FAO: Planning Department,  
Welwyn Hatfield Borough Council

Ref: 6/2022/0  
Date: 22/04/2022

## HISTORIC BUILDINGS AND CONSERVATION ADVICE

### **RE: The Old Vicarage Vineyards Road Northaw Potters Bar EN6 4NZ**

01 Site Plan
 1:100

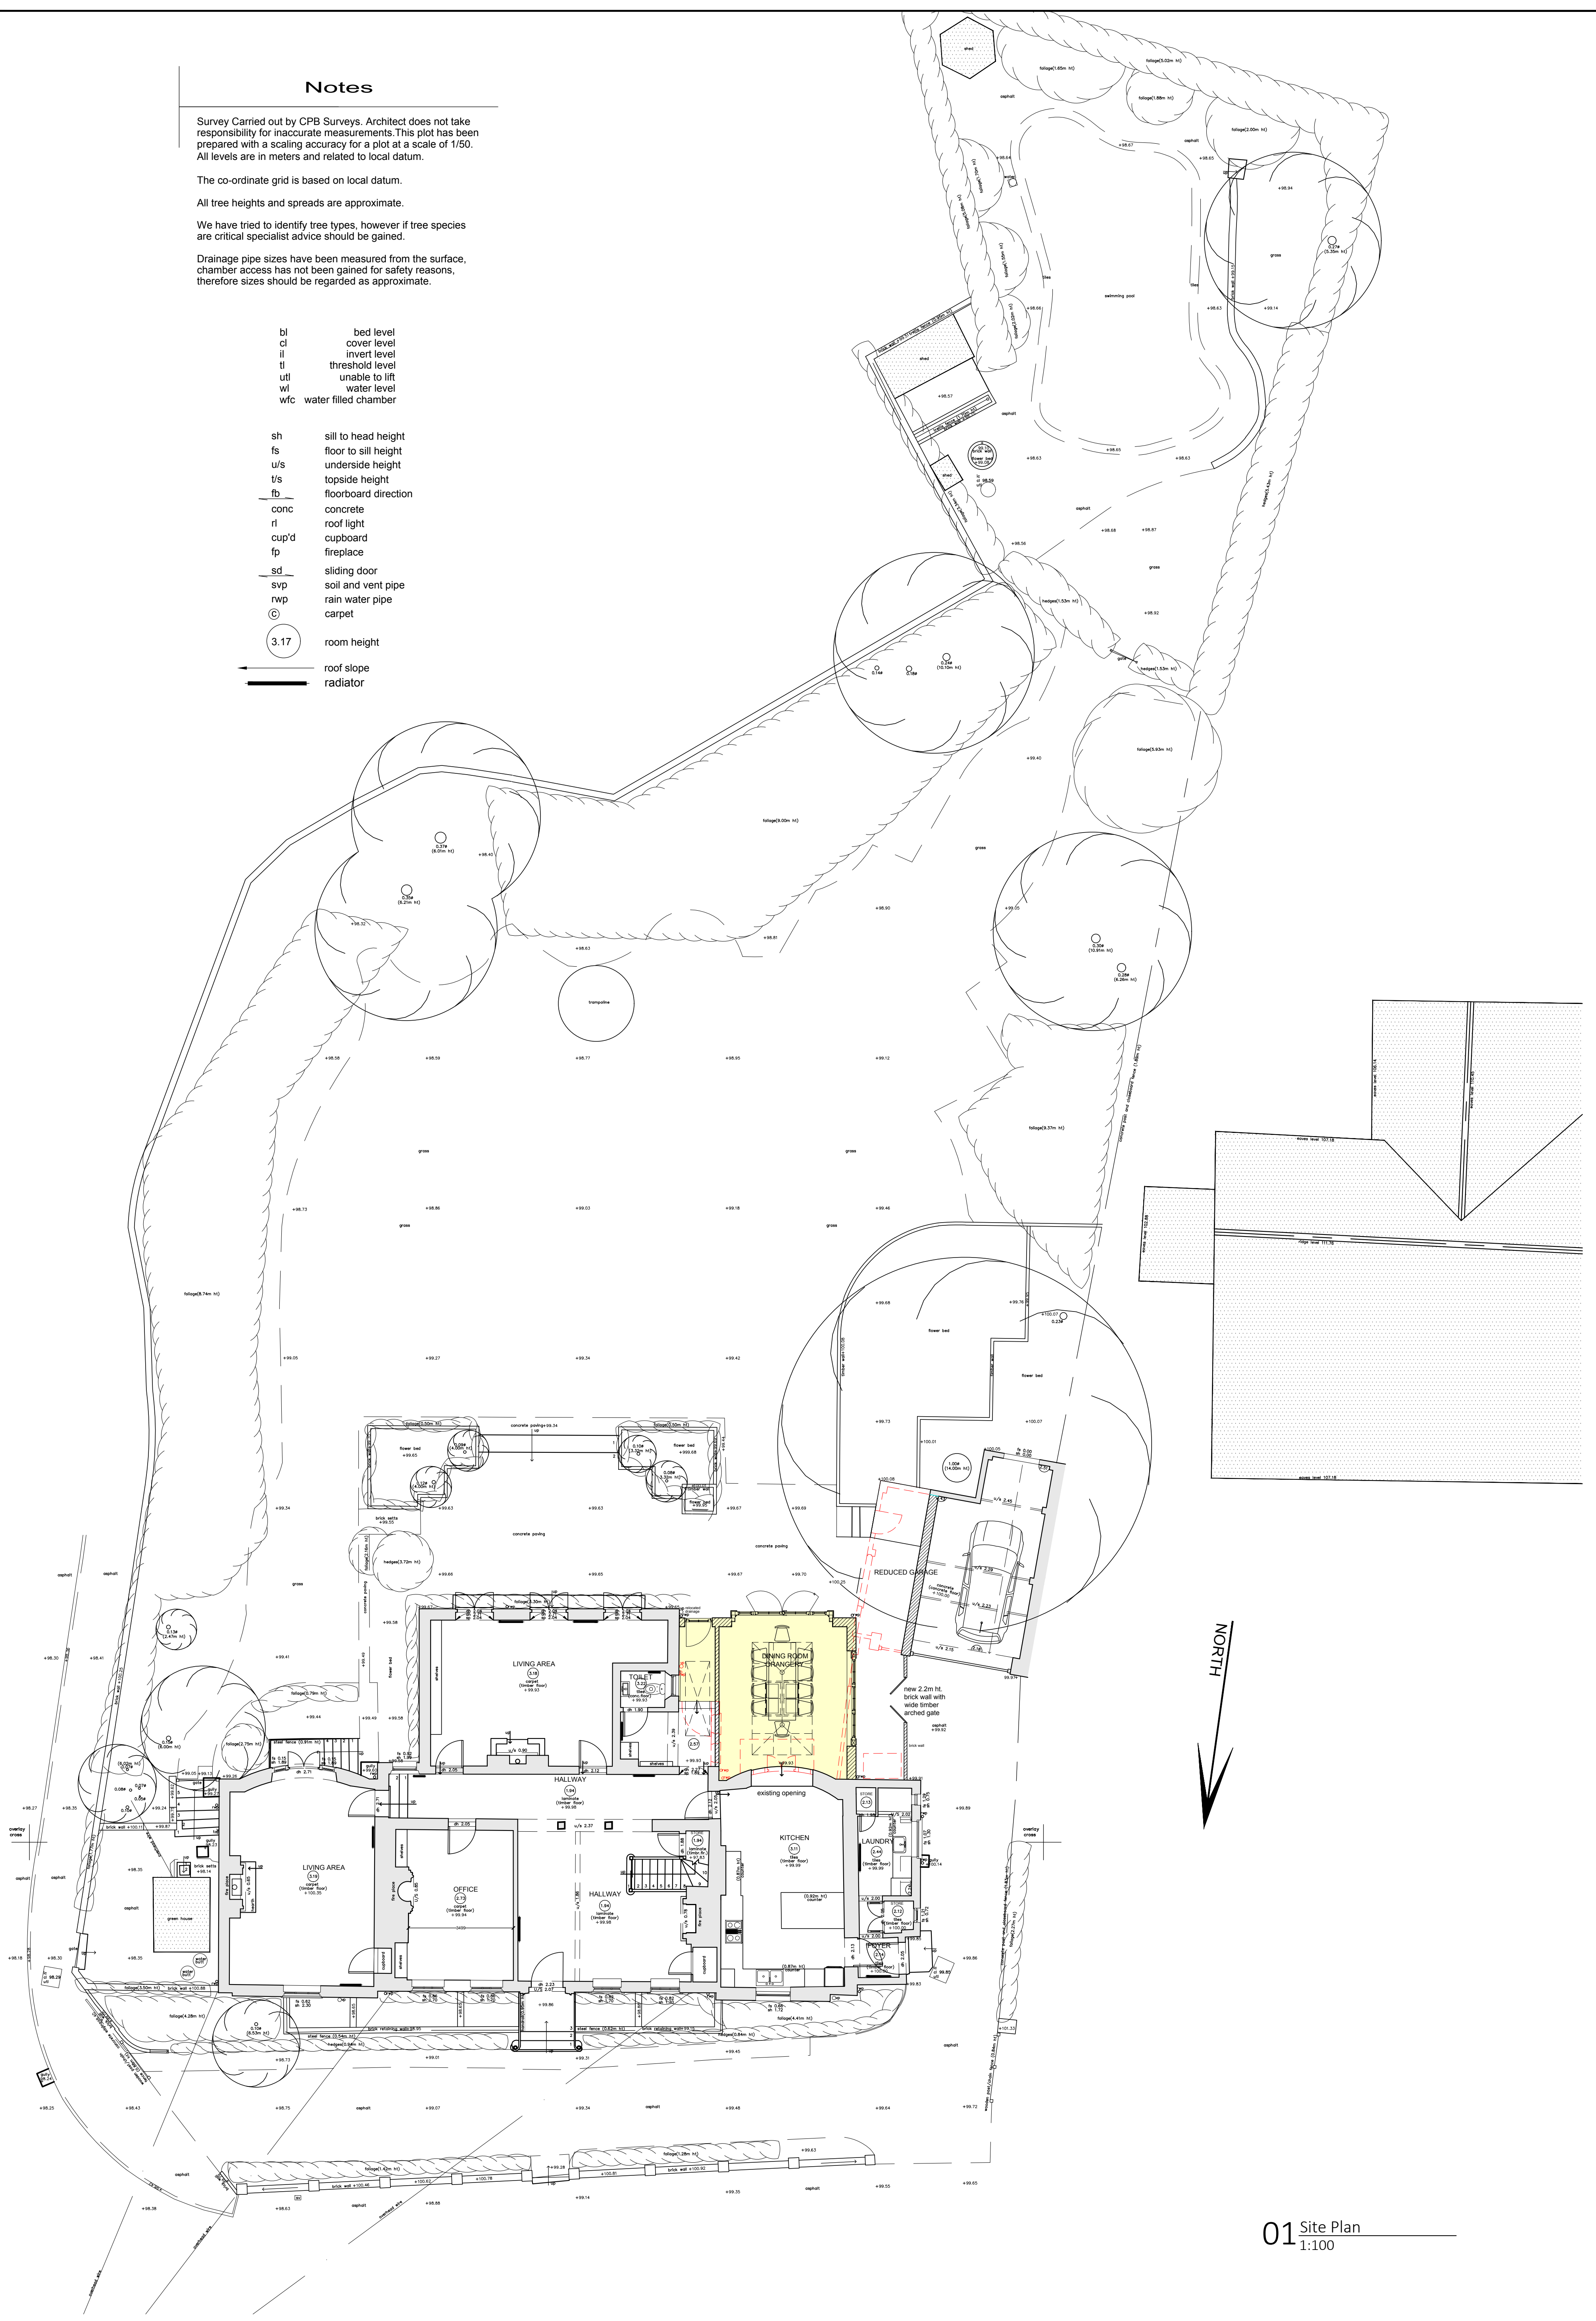
There are objections to the principle of a single storey rear extension in this location. While the double storey extensions are later additions, they date from the 19<sup>th</sup> century and it is clear that the design intention was to create a symmetrical appearance for the rear elevation. The symmetrical appearance is an important part of the attractive appearance of this elevation which has remained largely unaltered since the 19<sup>th</sup> century. A single storey rear extension in the location proposed would not only alter the symmetrical appearance it would also hamper the understanding of the development of the house and the design intention of the 19<sup>th</sup> century. Therefore, an extension in this location is not considered appropriate. A small extension may be better sited on the east side of the house, attached to the east wing, where ancillary buildings were formerly located. However, it is advised that before any new proposals are submitted for Listed Building Consent that pre-app advice is sought from the Welwyn Hatfield Borough Council.

There are no objections to the partial demolition of the garage.
